From: planning
Subject: FW: app3/2020/0093 Paddock Gate, 14 Wiswell La. Whalley #

From: Bloomer, David <David.Bloomer@lancashire.gov.uk>
Sent: 09 March 2020 07:43
To: Adam Birkett <Adam.Birkett@ribblevalley.gov.uk>
Subject: app3/2020/0093 Paddock Gate, 14 Wiswell La. Whalley #

PROPOSED SITE PLAN
Scale 1:200

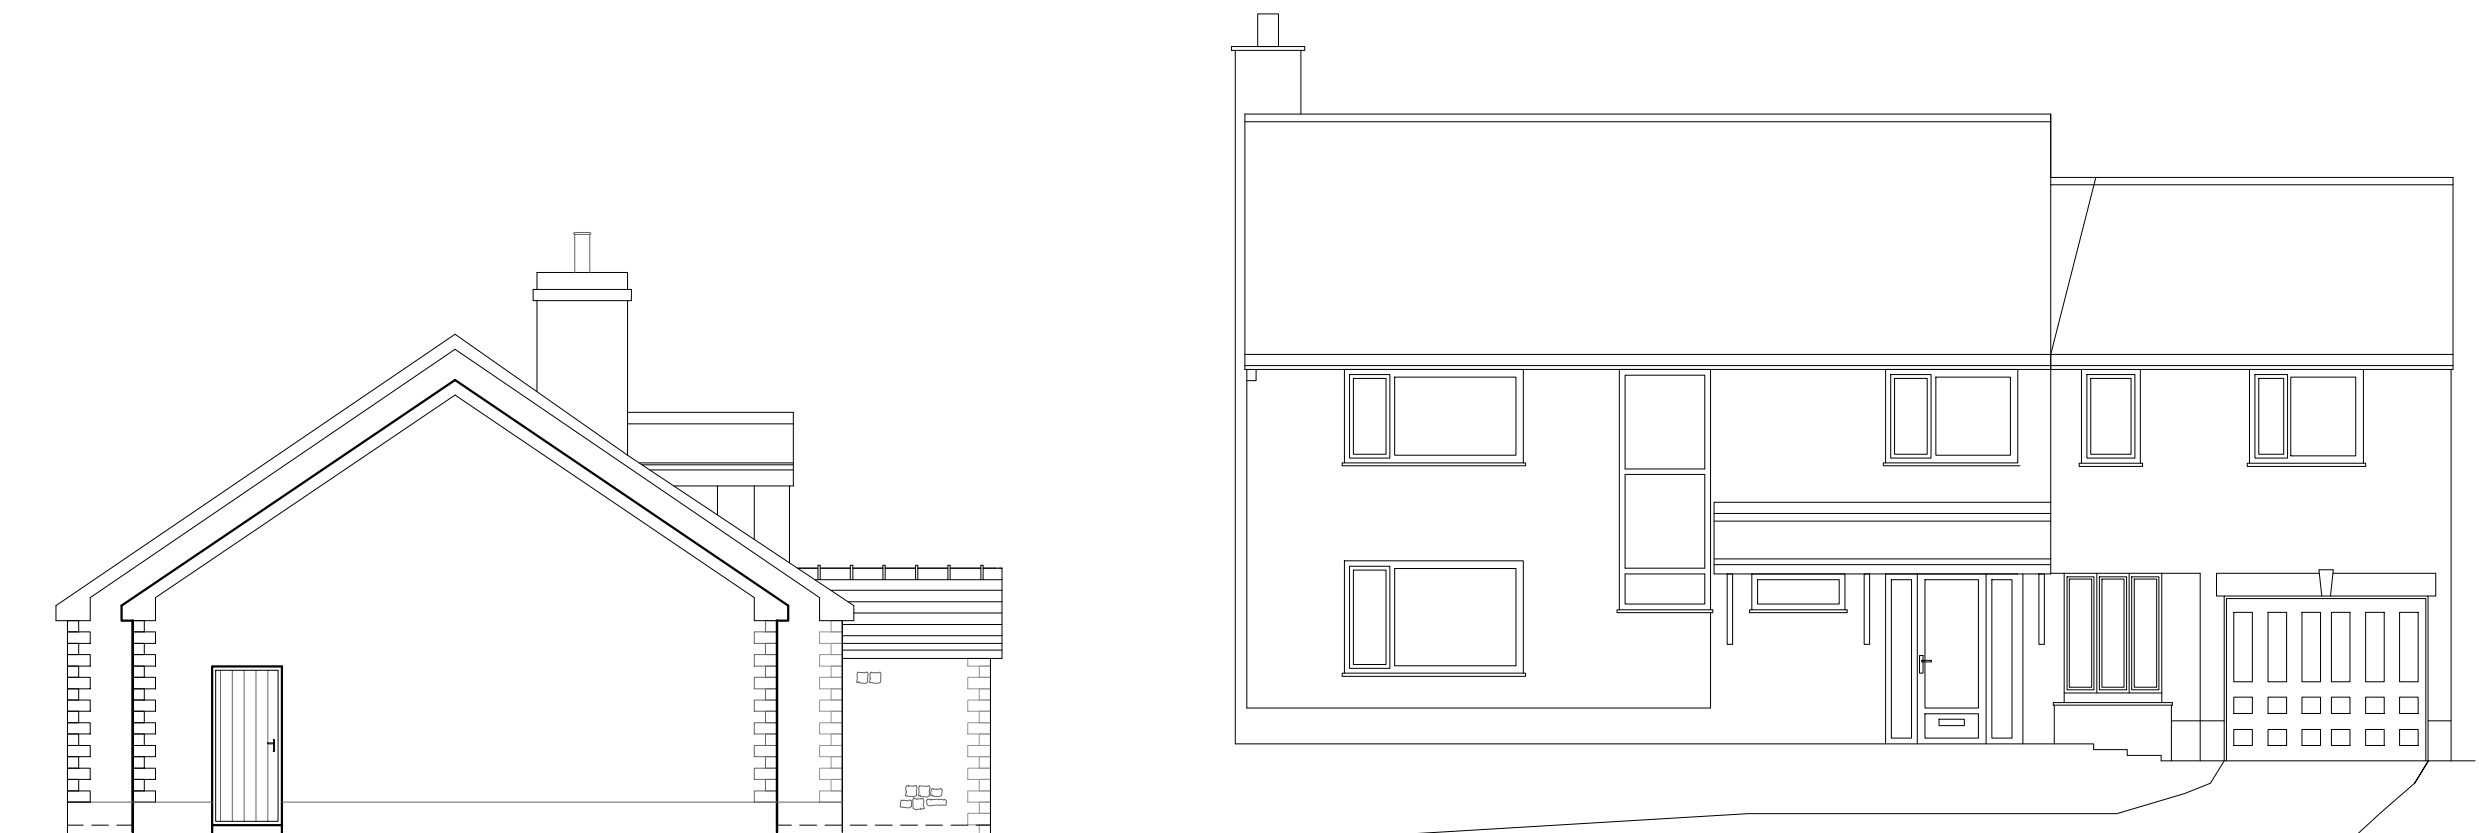
Thanks for the plan, the proposals for the entrance would be acceptable but the submitted plan makes no reference to the sightline requirement previously requested however having reviewed the site , and calculated the available sightlines within the highway boundaries I would be satisfied that the revised access detail would be sufficient betterment.

1. Before the access is used for vehicular purposes, that part of the access extending from the highway boundary for a minimum distance of 5m into the site shall be appropriately paved in tarmacadam, concrete, block pavements, or other approved materials. Reason: To prevent loose surface material from being carried on to the public highway thus causing a potential source of danger to other road users.
